# CITY OF ALBUQUERQUE

March 25, 2022

**Re: AVANYU RETAIL/ for building D, E, and F**  
**2400 12<sup>TH</sup> ST. NW**  
**30-Day Temporary Certificate of Occupancy**  
**Transportation Development Final Inspection**  
Engineer's Stamp dated 3-14-22 (H13-D113)  
Certification dated 3-2-22

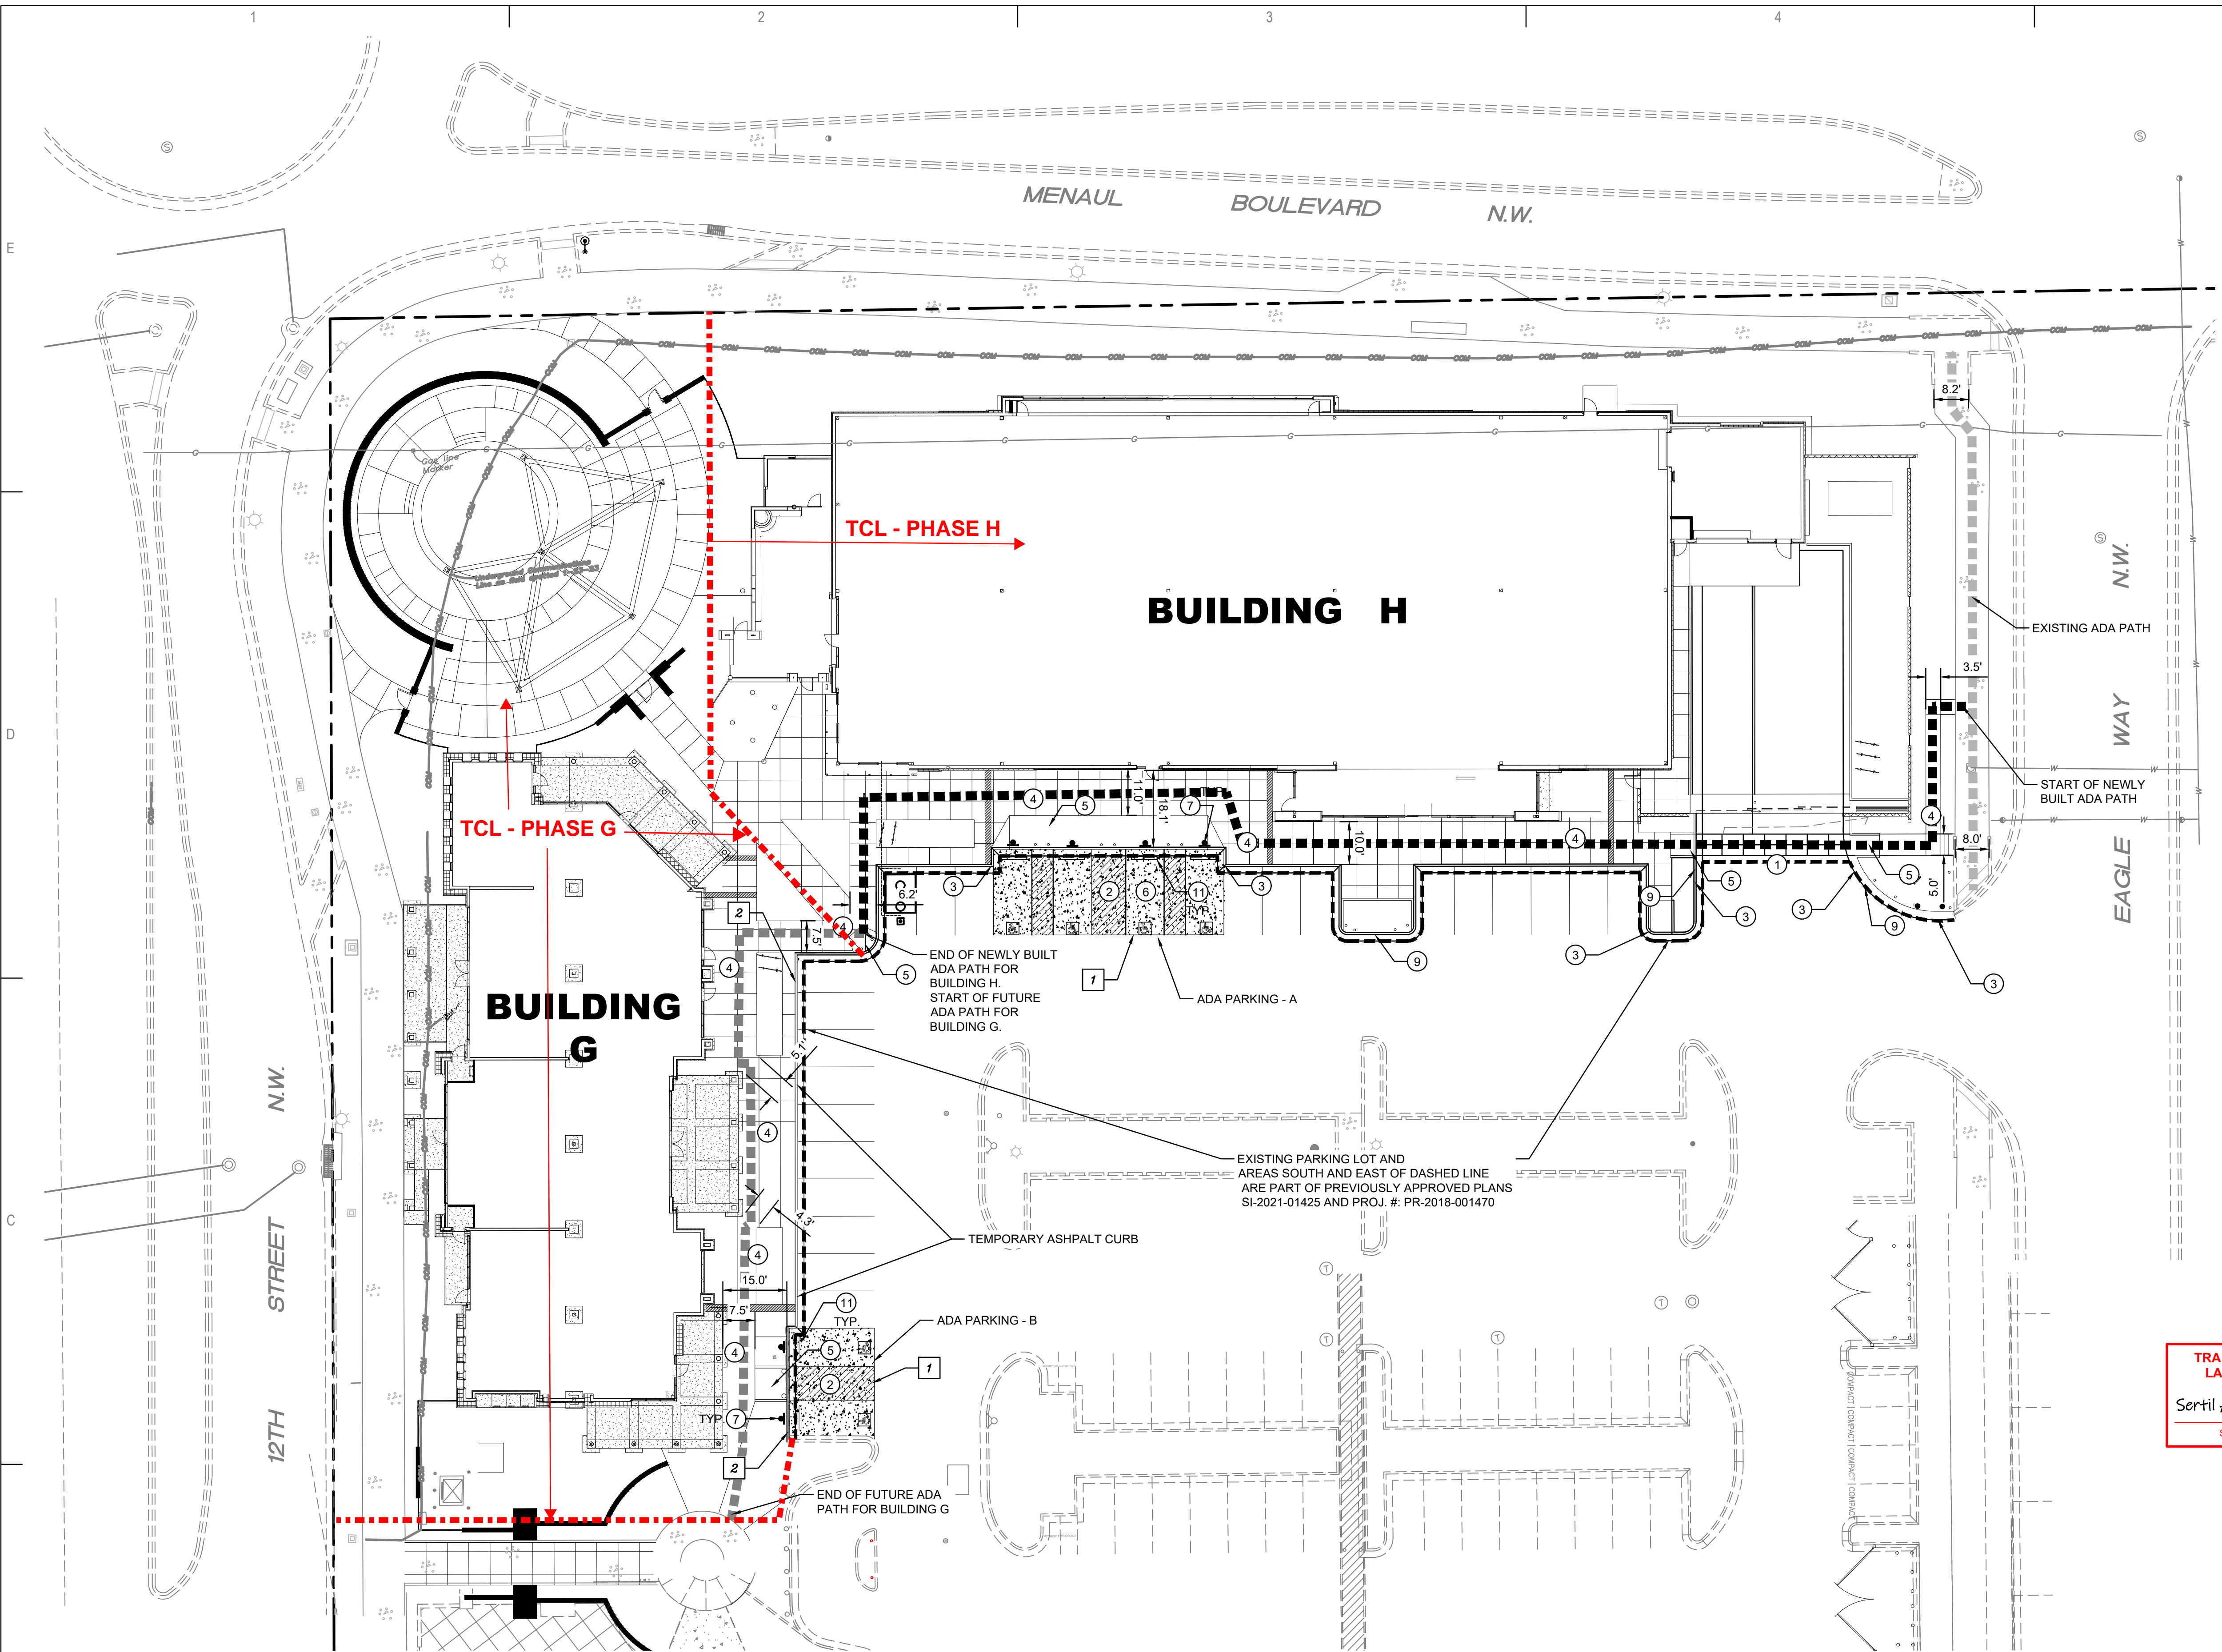
- Provide adequate Bicycle Racks per the approved site plan.
- Label the compact parking spaces by placing the words "**COMPACT**" on the pavement of each space.
- Key note23: At the northeast side of the site, ADA Ramp needs to be scraped to be flush with the ground.
- Key note4: sidewalk at the east side of building H has not been built per the approved site plan. Please address this concern.
- Provide 8 on-street parking spaces per approved site plan. Please remove the first on-street parking space that close to the driveway entrance for clear sight issue.
